# Lincoln/Haney Engineering Associates, Inc.

October 28, 2014

Re: Review of structural impact from increasing wall openings

Dining Rm into Living Rm Opening  
(#3 on floor plan)

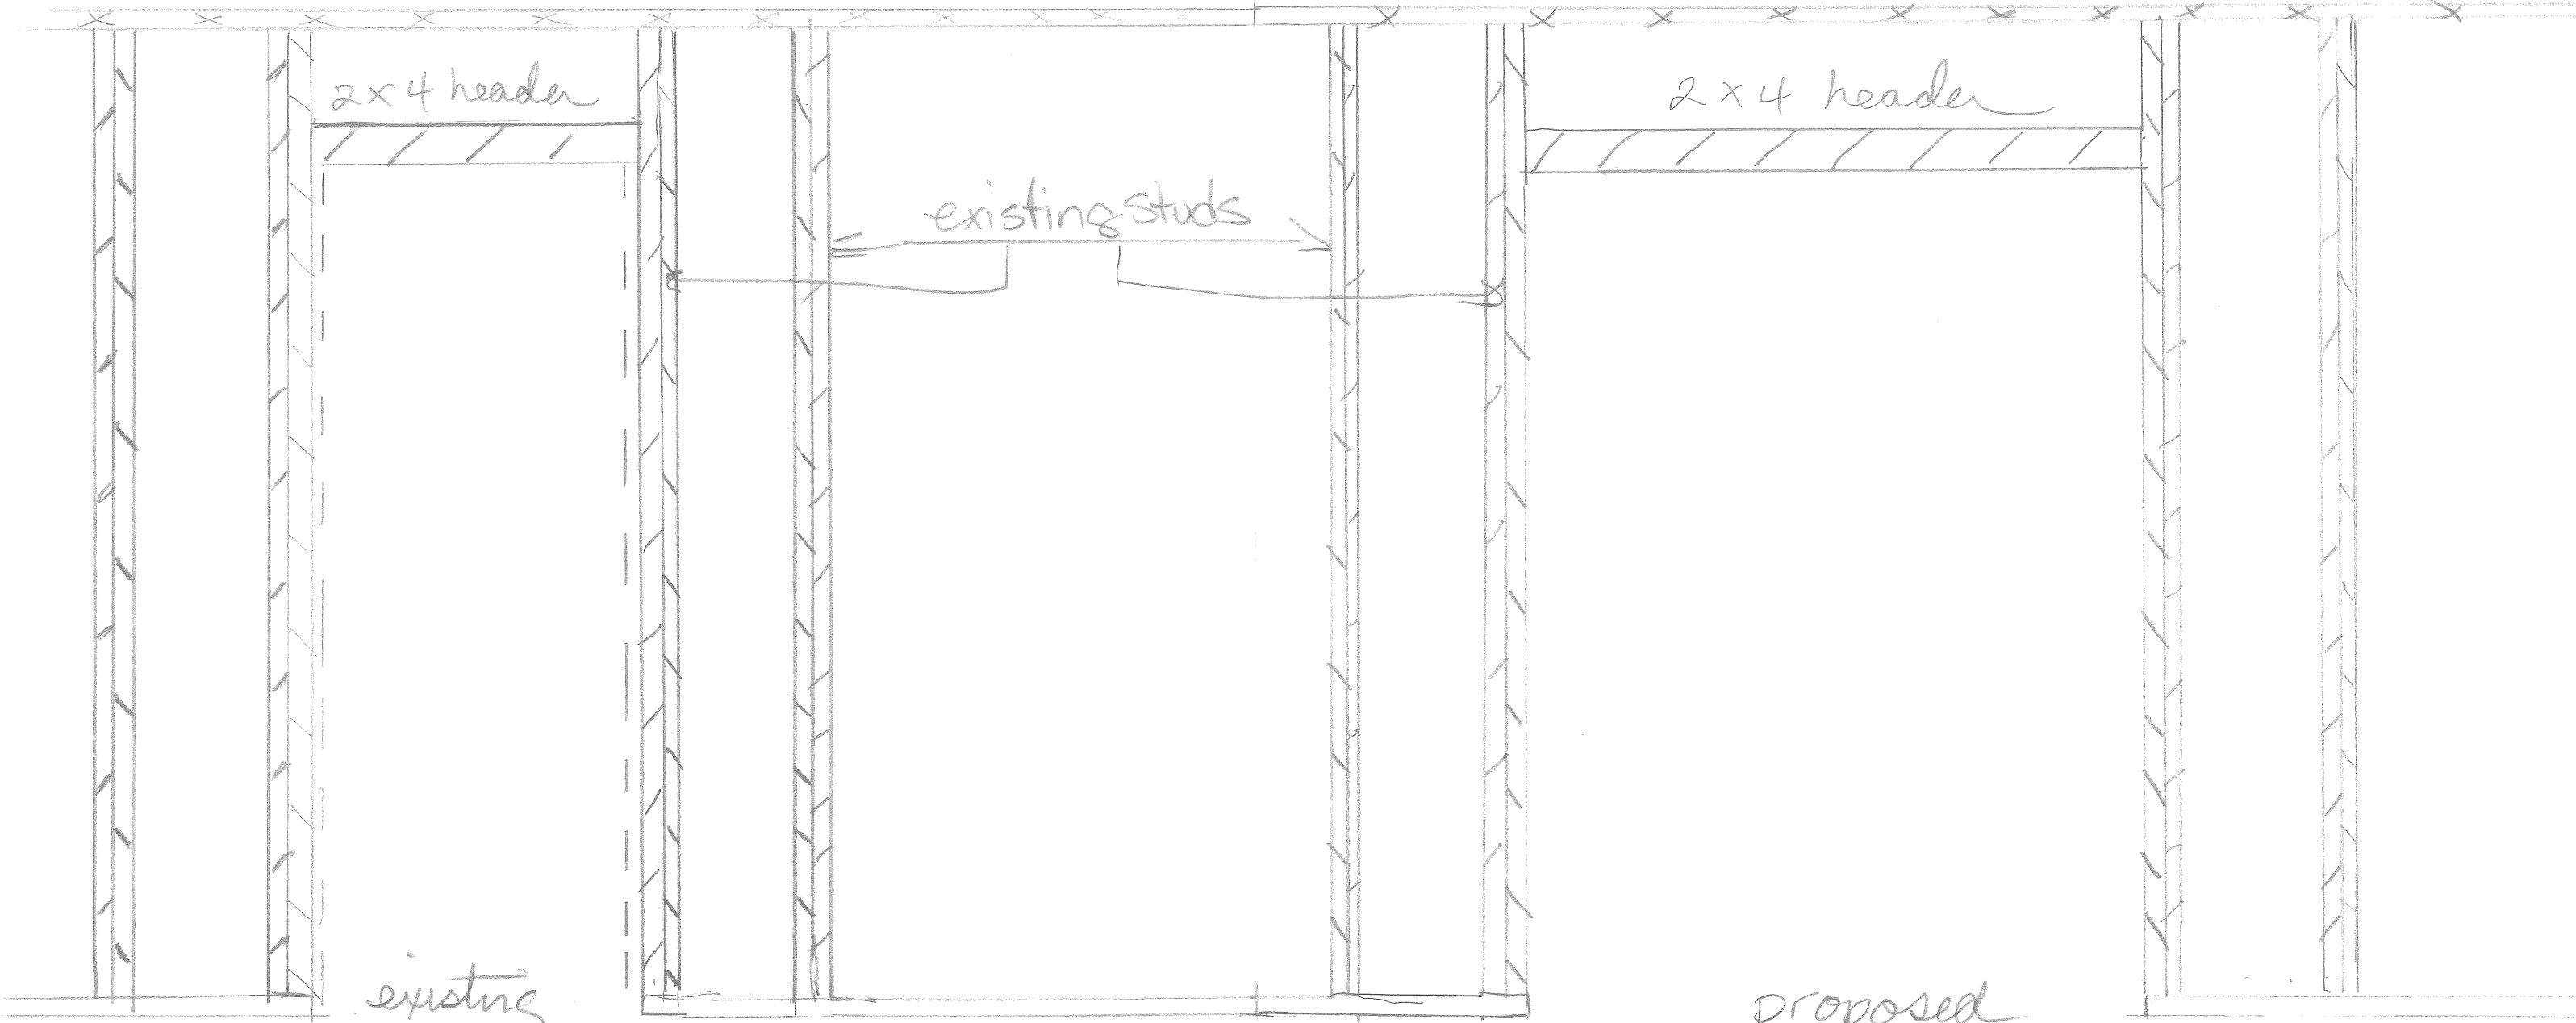
Regarding the planned renovations, the load-bearing portion of the wall that contains openings #1 and #2 does not extend to opening #1. It does extend about 3' into the widened 6' opening #2. However, since the joists are continuous over the top of the wall without splices and the spans on either side of the wall are only 3'-6" and 5'-6", it is not necessary to provide temporary support for the roof construction during demolition. This assumes that the demolition and reconstruction can occur when there is not a significant snow load on the roof. I do recommend that the header utilized to span the new 6 foot opening consist of 2-2x8 members of #2 Spruce-Pine-Fir, or better. The wall that contains opening #3 is parallel with framing members and, therefore, is not load-bearing.

To summarize, I find that openings #1 and #3 do not occur in load-bearing walls. Standard details for framed openings in a non-bearing partition may be utilized. At opening #2, approximately 1/2 of the opening is within a load-bearing portion of the wall. But because the rafters above are continuous over the wall with short spans on both sides of the wall, shoring of the roof construction is not required during construction unless that construction is delayed to
